Subject: Response To Application Number EP/4/19/PL at 56 St. Marys DriveLittlehamptonBN16 1JB

TO:	Arun District Council FAO: A. Gardner
FROM:	WSCC - Highways Authority
DATE:	5 March 2019
LOCATION:	56 St. Marys Drive Littlehampton BN16 1JB
SUBJECT:	EP/4/19/PL Conversion of office building (B1 Business) to 2 No. 2 bedroom self contained flats (C3 Dwelling houses).
DATE OF SITE VISIT:	N/A
RECOMMENDATION:	Advice
S106 CONTRIBUTION TOTAL:	£N/A

This proposal is for the conversion of an office building to 2 x 2 bedroom flats.

2356 / 18 / 01	Rev. A
-----------------------	---------------

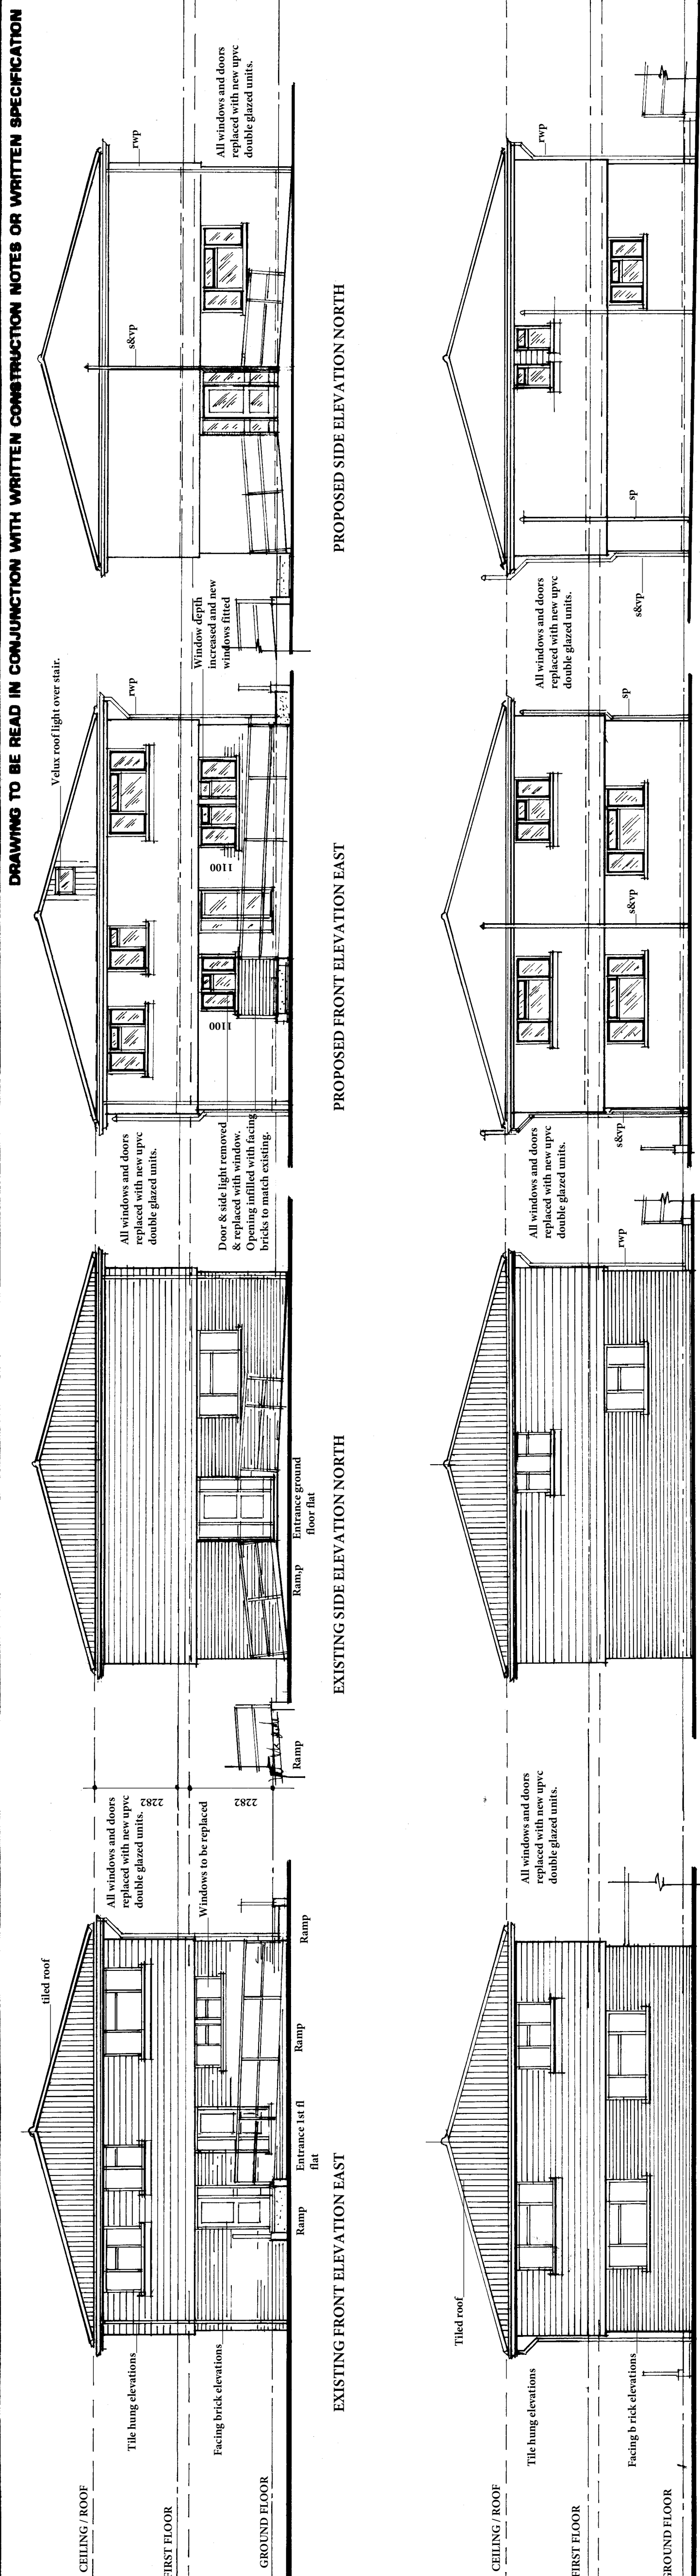
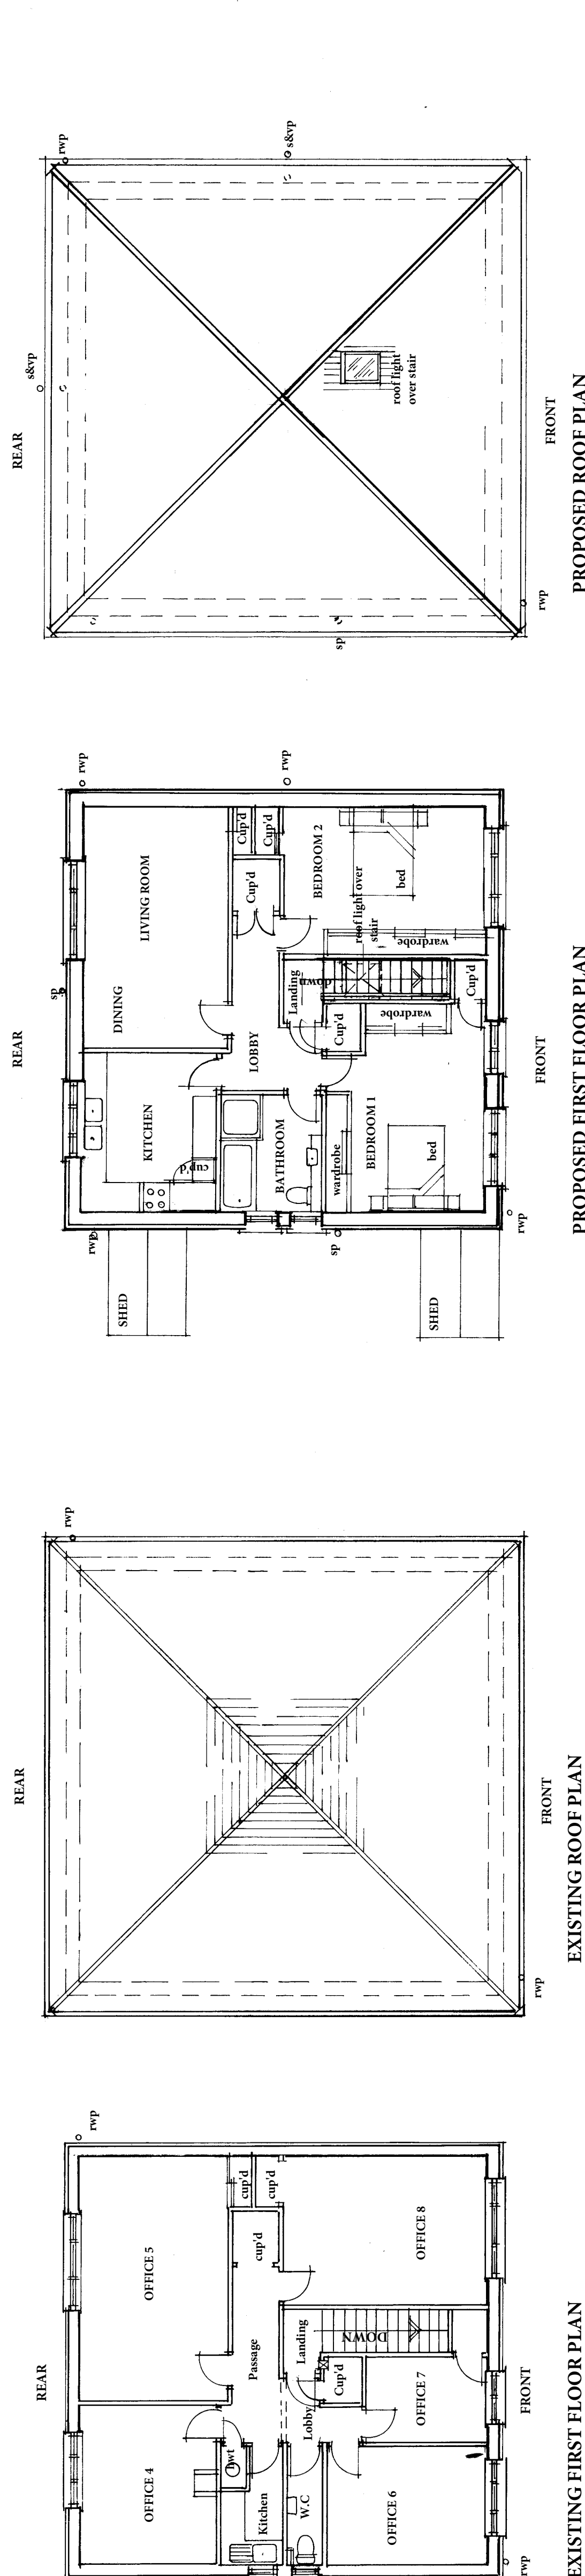
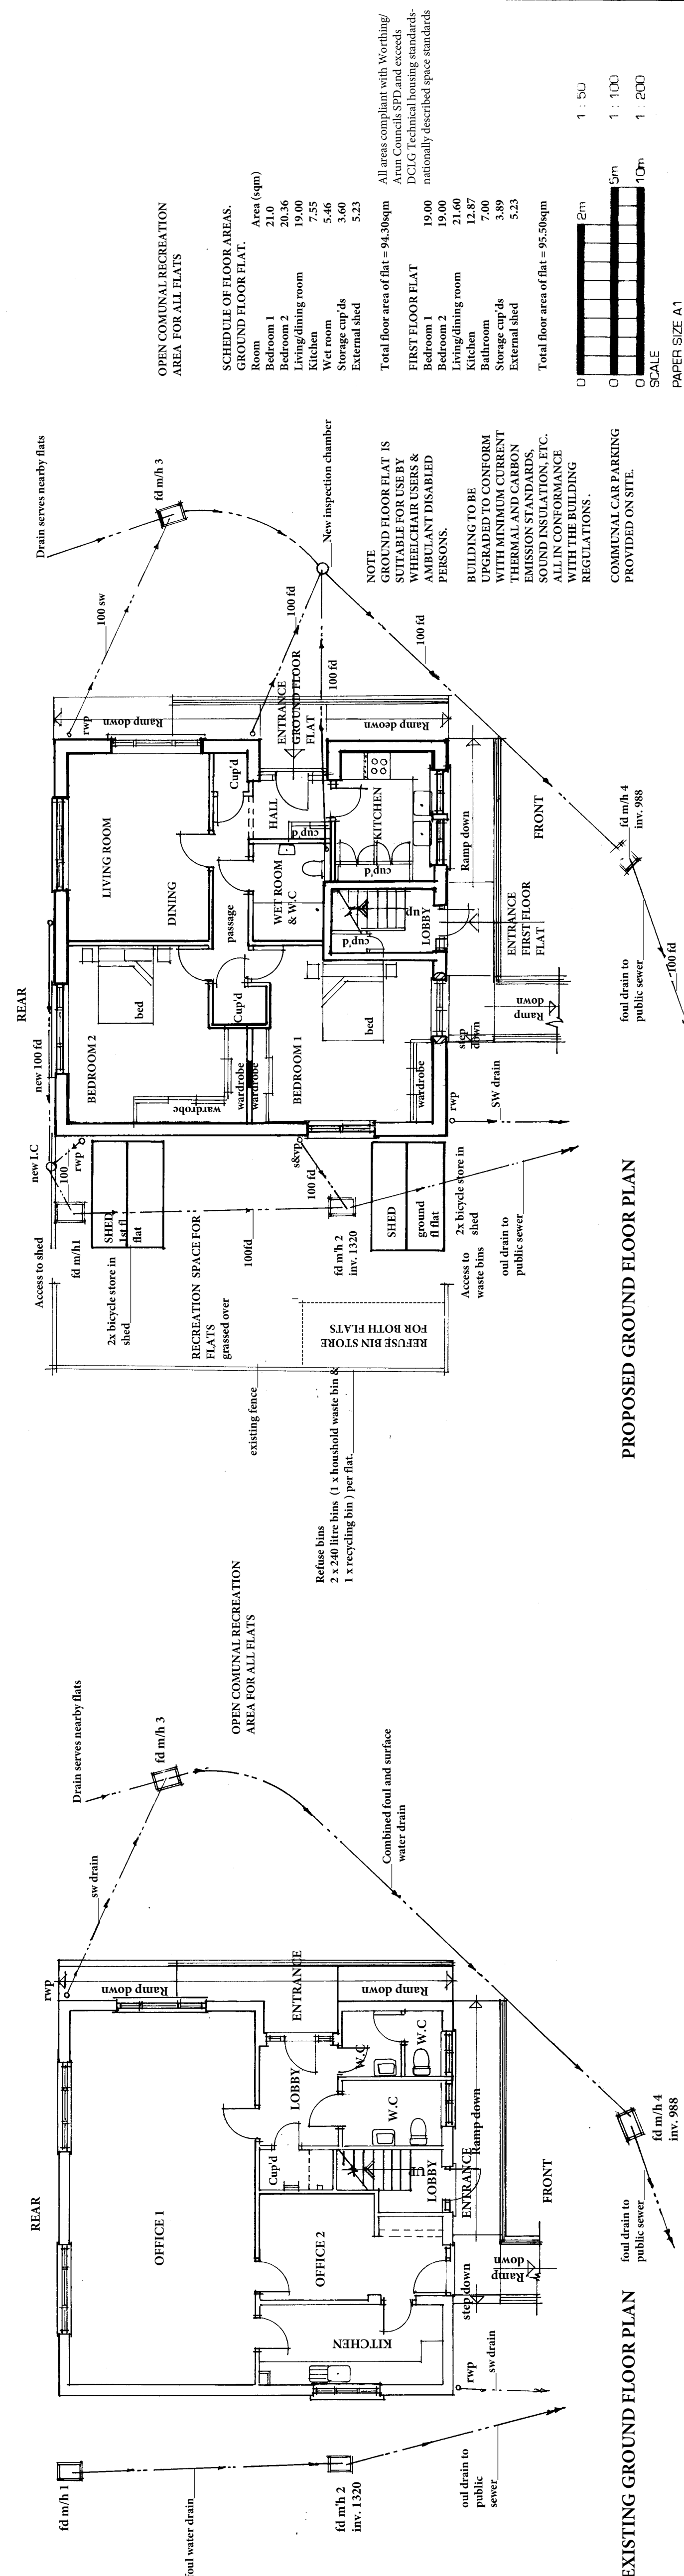
The site is located on St Marys Drive, an unclassified residential road subject to a 30 mph speed limit. The plans show that no parking spaces or garages are provided; therefore there are no points of access. An inspection of data supplied to WSCC by Sussex Police over a period of the last five years reveals that there have been no recorded injury accidents within the vicinity of the site.

The plans indicate that no off-street parking provision will be provided for the proposed dwelling. Using the WSCC Car Parking Demand Calculator, the size and location of this dwelling determines that at least 2 car parking spaces is required. Any overspill parking as result of this proposal could be accommodated on-street. We would not consider that highway safety would be detrimentally affected through the proposed nil car parking provision. The Planning Authority may wish to consider the potential impacts of this development on on-street car parking from an amenity point of view.

The property is situated close to local shops, services and schools. Furthermore, it is well connected to bus routes and is within walking distance of Angmering Train Station. Therefore the location reduces the need for travel by car. The plans have provided cycle storage for 4 cycles, which is sufficient for the needs of the property.

No part of the development shall be first occupied until covered and secure cycle parking spaces have been provided in accordance with the approved plan.
